EP-24-0077 Monument Ridge East
N½ Section 2, T11S, R67W, 6th Meridian
39.1284, -104.8624
File Number: SP241
Preliminary plan to create 342 residential lots on 63 acres.

With this referral, we received a request to provide Review Comments (Email dated 6/13/2024); Construction Drawings (Drexel, Barrell & CO., January 3, 2024); Preliminary Drainage Report (PRC Engineering, April 2024); Preliminary Plan Drawings (Bear Creek Surveying, Inc., 4/12/2024); Soil and Geology Study (Entech Engineering, Inc., 3/7/2023), and other documents. We offer the following comments and recommendations.

Submitted 6/13/2024 by Amy Crandall, Colorado Geological Survey: acrandall@mines.edu

**MONUMENT RIDGE EAST**  
**EAST & WEST PARCEL**  
**GRADING EXHIBIT**

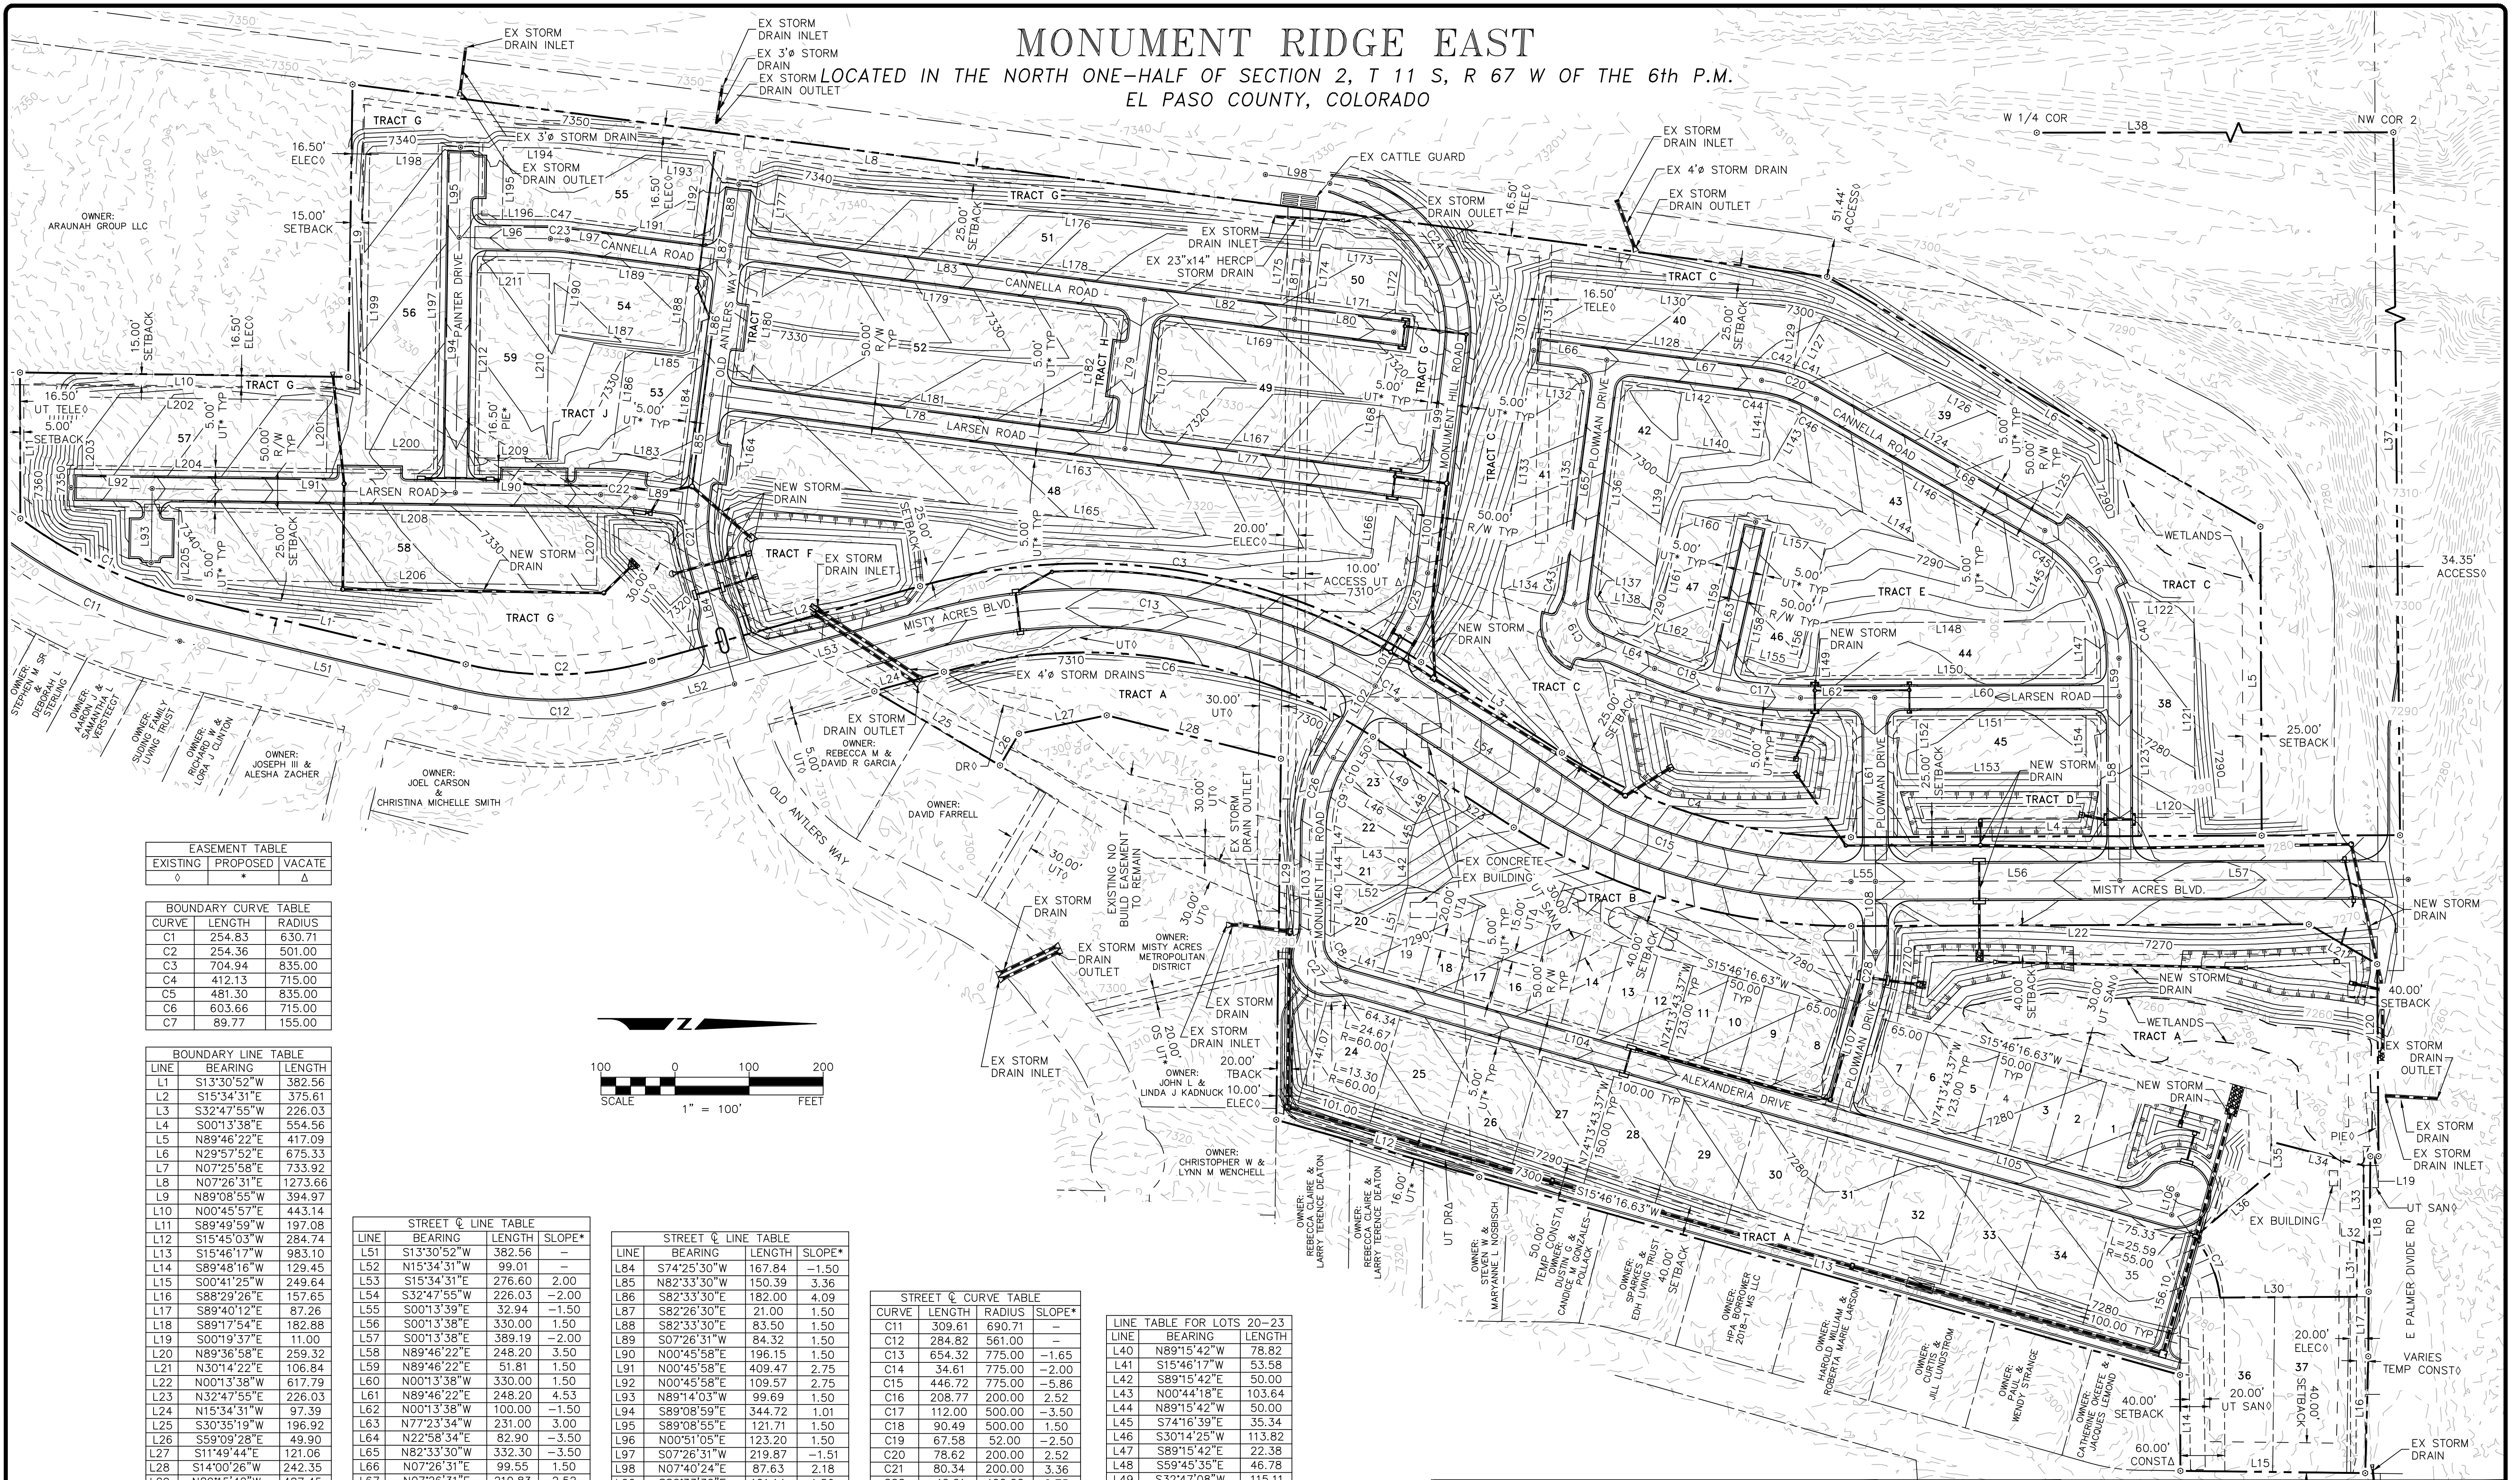
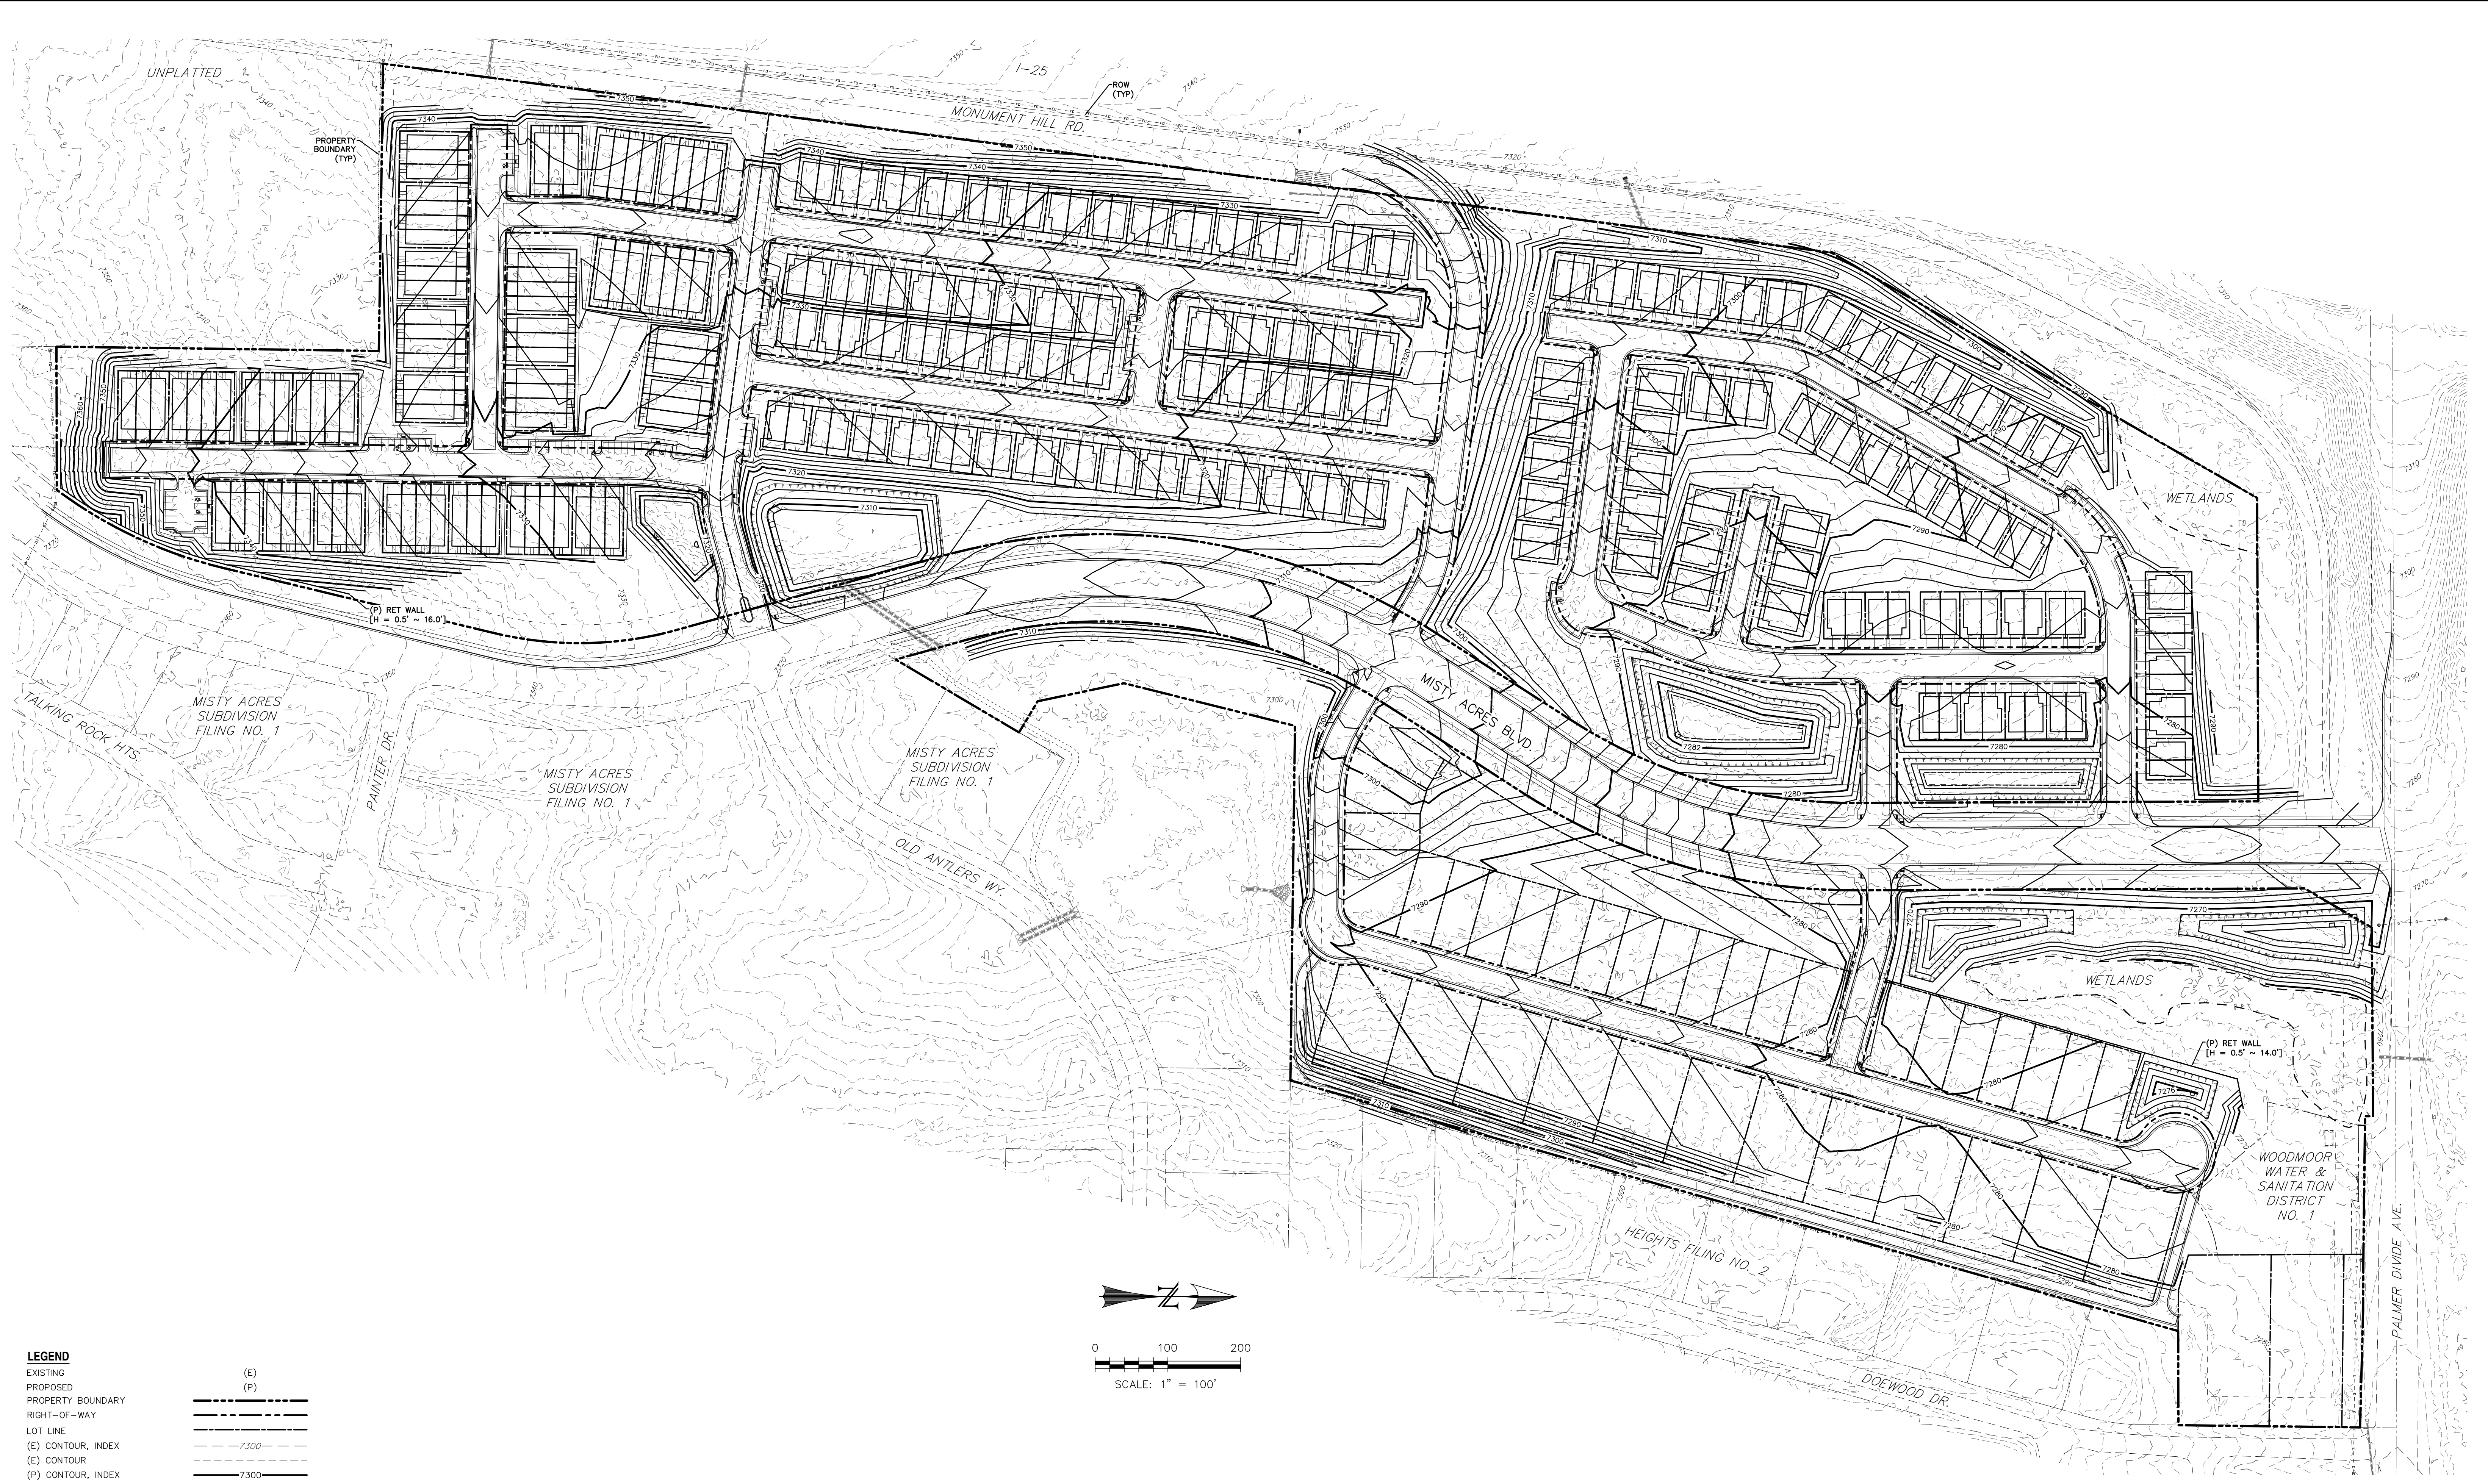
2. Entech states (page 11), “*Proposed grading plans indicate these areas that have been mapped in lot areas will be filled and raised above the seasonally shallow and potentially seasonally shallow groundwater areas.*” In our cursory review of the preliminary plan with existing and proposed grades, it appears that most of the site will contain significant cuts to achieve the proposed grades, in some areas up to 20 feet. Due to the shallow groundwater conditions at this site and the cuts planned, **no basements should be allowed.**

6. CGS has concerns with lots and future improvements constructed over the existing drainage that runs north and south through the site, even following grading operations, as this natural drainage can be an area where water will continue to migrate. CGS recommends that if lots are planned (or allowed) within/near the existing drainage (after rerouting and site grading occurs), these areas be further evaluated during site-specific geotechnical investigations to determine the impact (i.e., groundwater conditions, differential settlement, etc.) on future development. It would be prudent to install a drain system within the existing drainage prior to grading operations if it is not planned already.
